From: Daun Johnson on behalf of Planning
Sent: 21 September 2026 08:04
To: Planning Scanning
Subject: FW: FTAO Hebe Smith - Planning application comment FG/87/26/PL

FG/87/26/PL

42 Sea Lane Ferring BN12 5EH

Demolition of the existing dwelling and garages and erection of 4 No. terraced dwellings at the site's frontage, and 2 No. detached dwellings at the rear. Access from Sea Lane. Replacement garage to serve No.36 Sea Lane Gardens. In CIL Zone 4 and is CIL Liable as new dwellings.

Fig 6. Proposed Site Plan

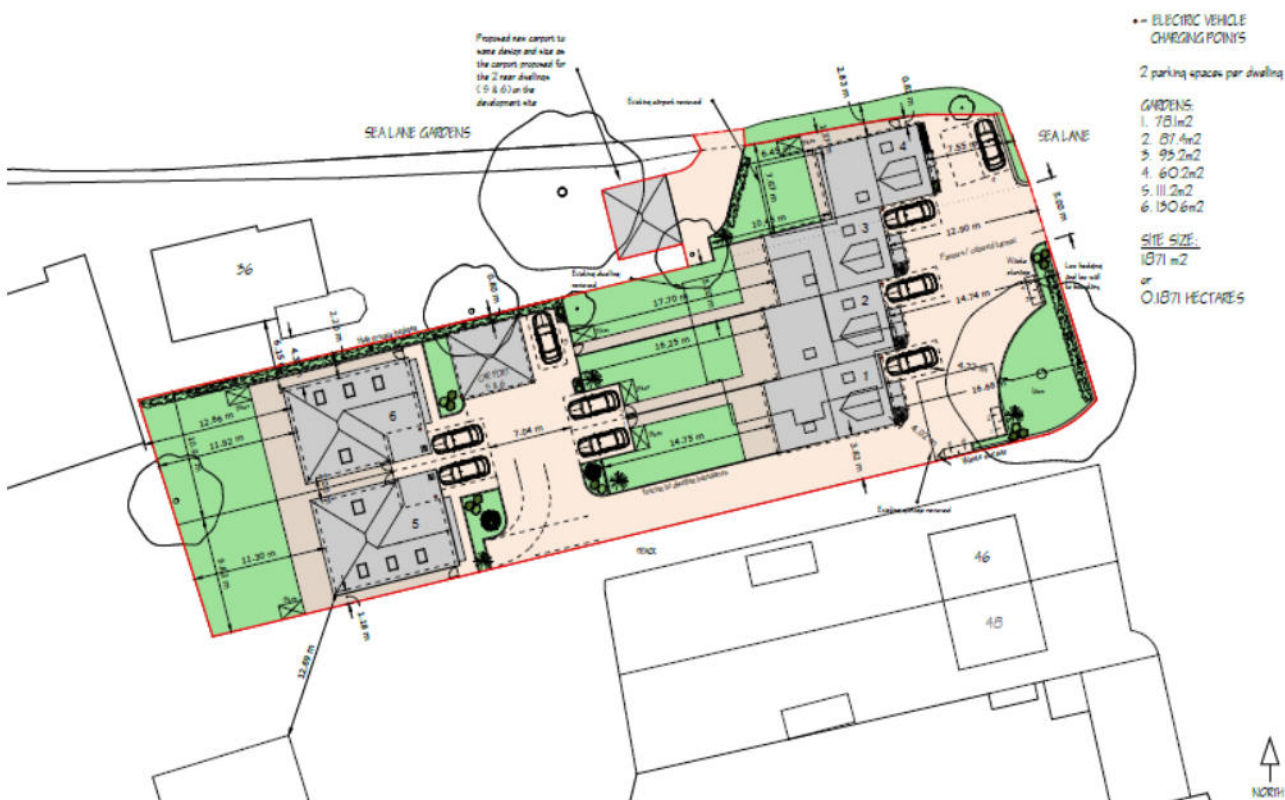
Cars exiting the parking bays assigned to plots 1 and 2 will likely encroach the 'no dig' root protection area indicated on the ground plan due to limited space to manoeuvre to achieve an exit in forward gear onto the highway (as would large vehicles coming from the rear of the site).

When the parking spaces for plot 4 are occupied, any vehicle reversing from the plot 3 parking provision will need to make multiple manoeuvres across the entrance, potentially prohibiting any vehicle attempting to enter the site from doing so.
